PLANNING BOARD REPORT PORTLAND, MAINE

Bishop Street Apartments
72 Bishop Street
Level III Site Plan and Subdivision Review
2015-060
Avesta 72 Bishop Street, LP

Submitted to: Portland Planning Board
Date: July 10, 2015
Public Hearing Date: July 14, 2015

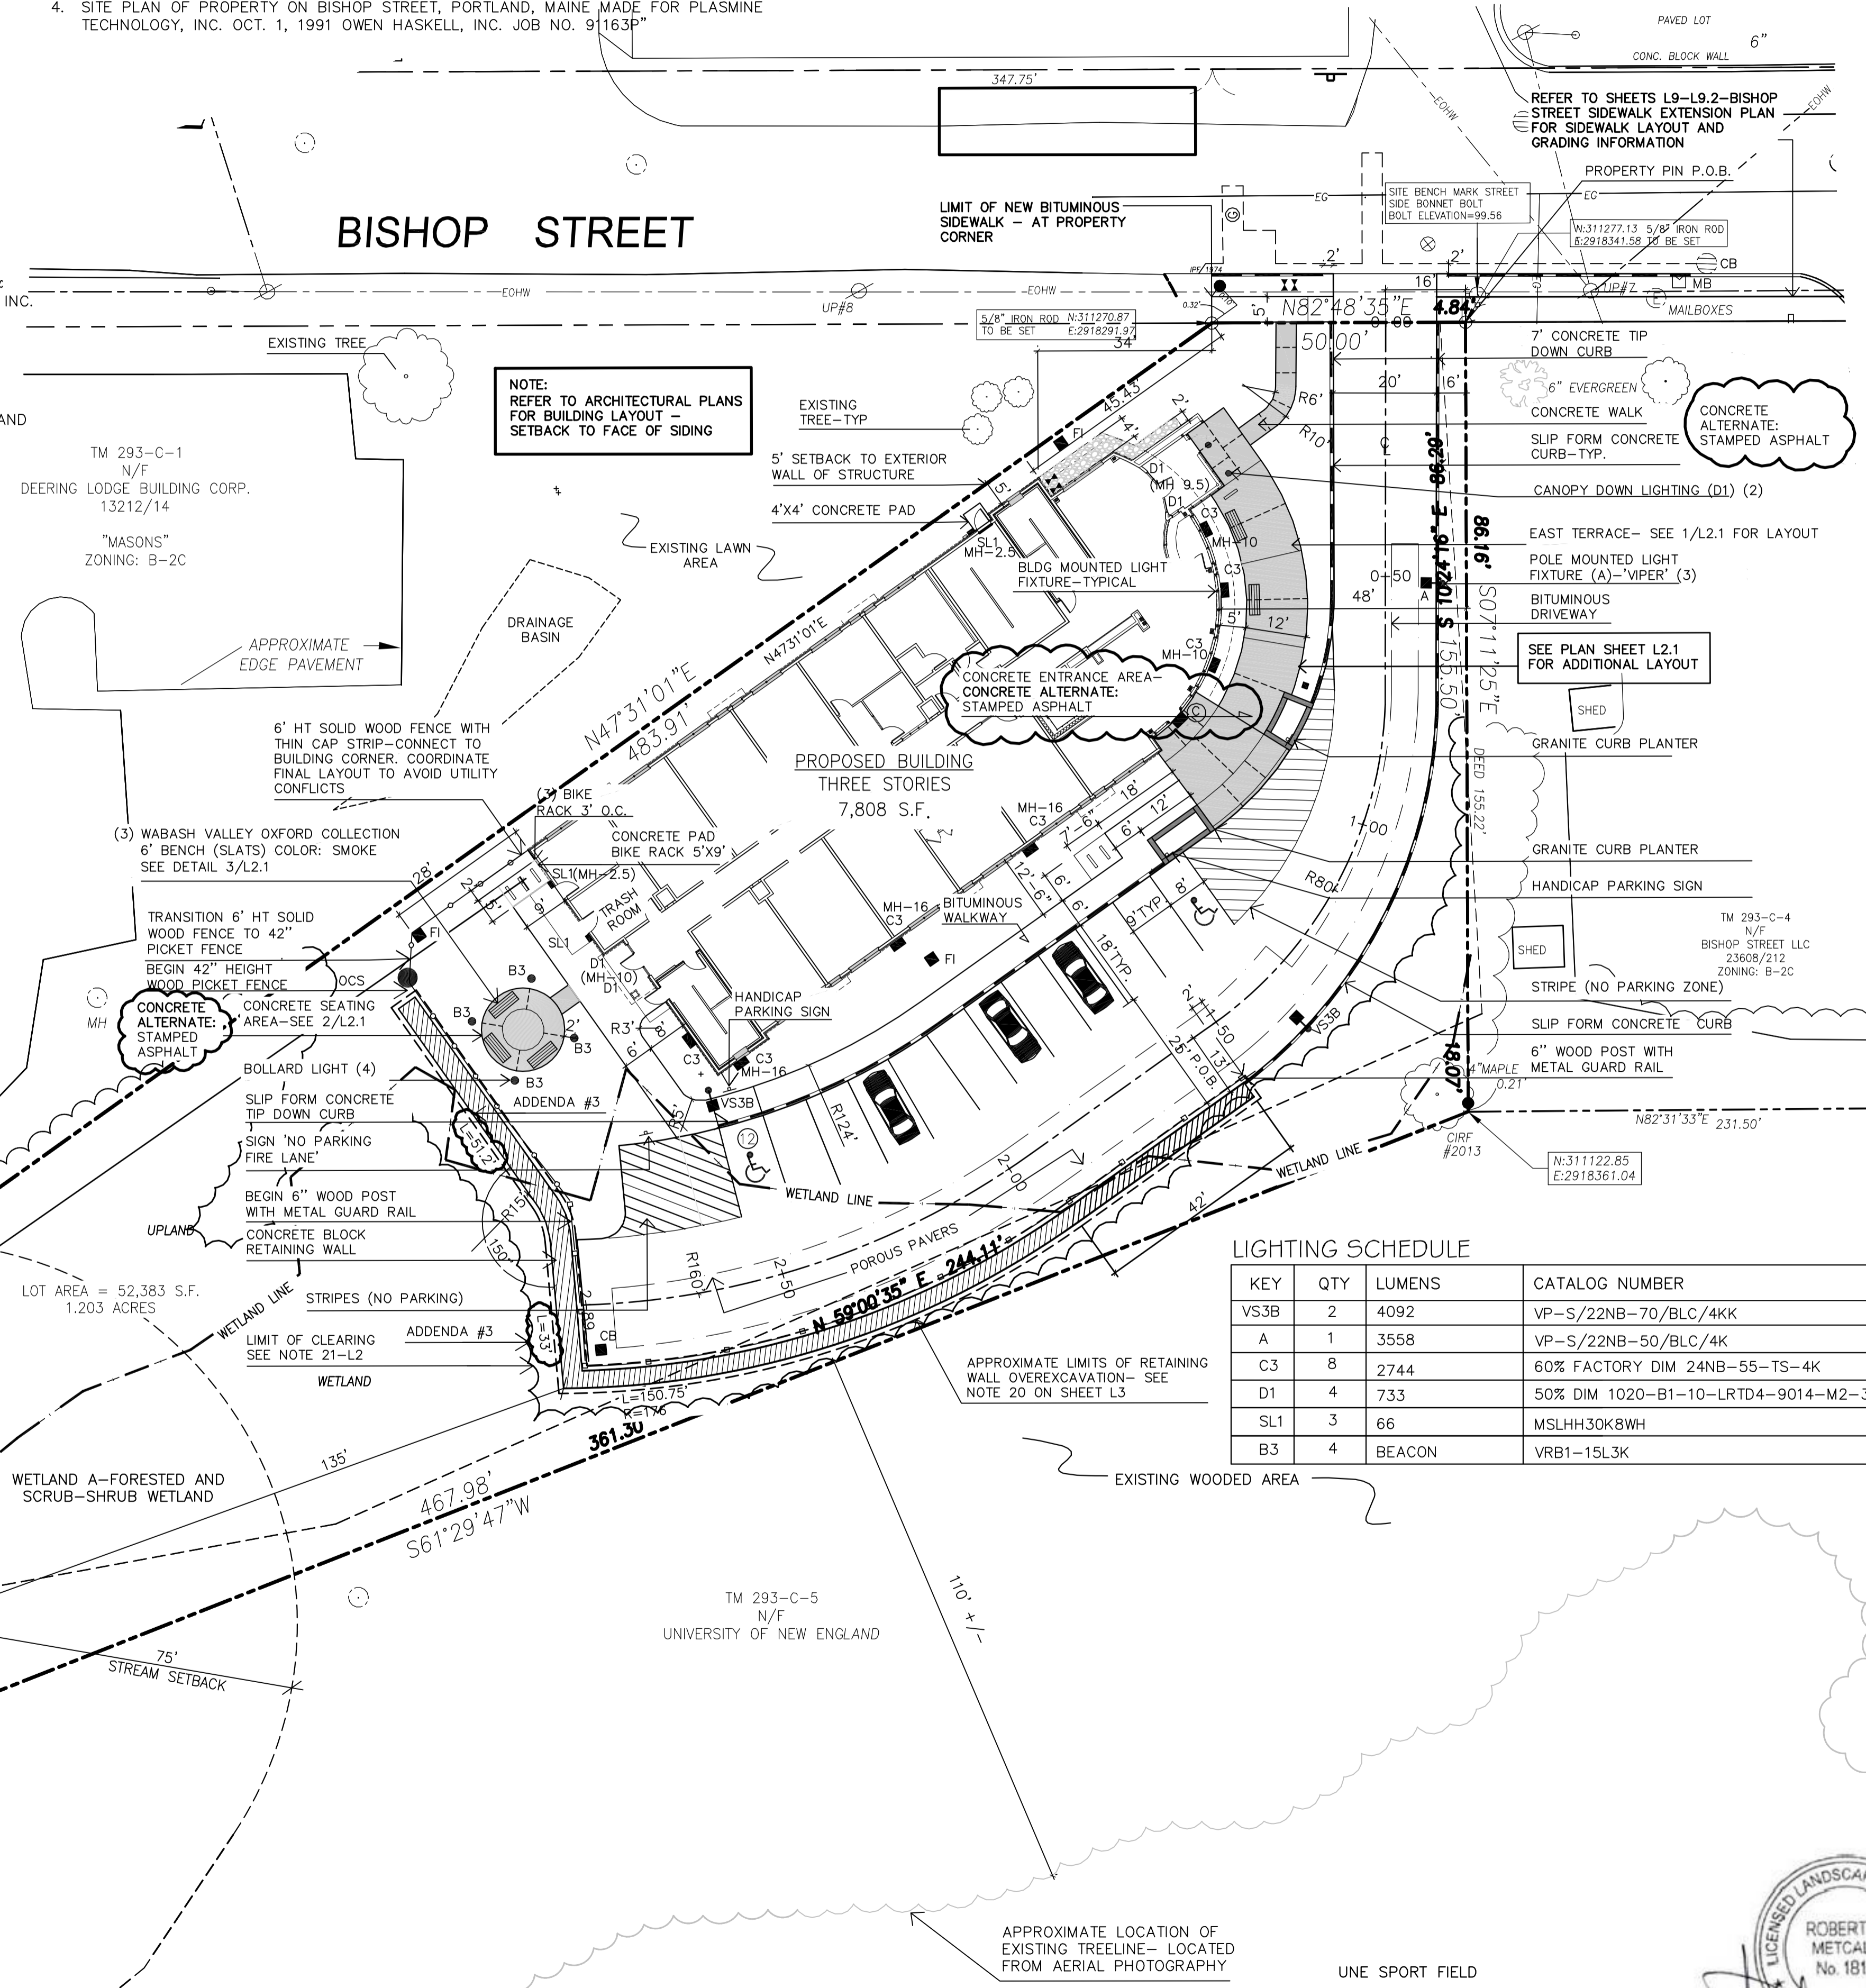
1. *Front Yard Maximum.* The B-2c zone establishes a front yard maximum of 10 feet, which the applicant continues to propose to exceed. At its closest point, the building is planned to sit 18 feet from the front property line (*Figure 5*). The ordinance does provide for an exception, stating that “the Planning Board or Planning Authority may approve a different amount for irregularly shaped lots or lots with frontage less than 40 feet provided this standard is met to the maximum extent practicable” (*Section 14-185*). The applicant has claimed in their site plan submittal that 72 Bishop is an irregularly shaped lot and that they have sited the building as close to the street as possible. The applicant writes,

The B-2 dimensional requirements also include a provision that, “[w]here setbacks exceed 10 feet, a continuous, attractive, and pedestrian-scaled edge treatment shall be constructed along the street, consisting of street trees spaced at no more than 15 feet on center, approved by city arborist, and a combination of landscaping no less than 4 feet deep, ornamental brick or stone walls or ornamental fencing” (*Section 14-185*). In the revised submittal, the applicant has added perennials/groundcover, hackberry and red maple trees, and azaleas and daphnes in the space between the building and the street line in an effort to provide sufficient edge treatment in this location (*Figure 5*). The arborist has reviewed the plans and generally found them satisfactory. The applicant is requesting that the board approve the project with the proposed deviation from the front yard maximum of the B-2c.
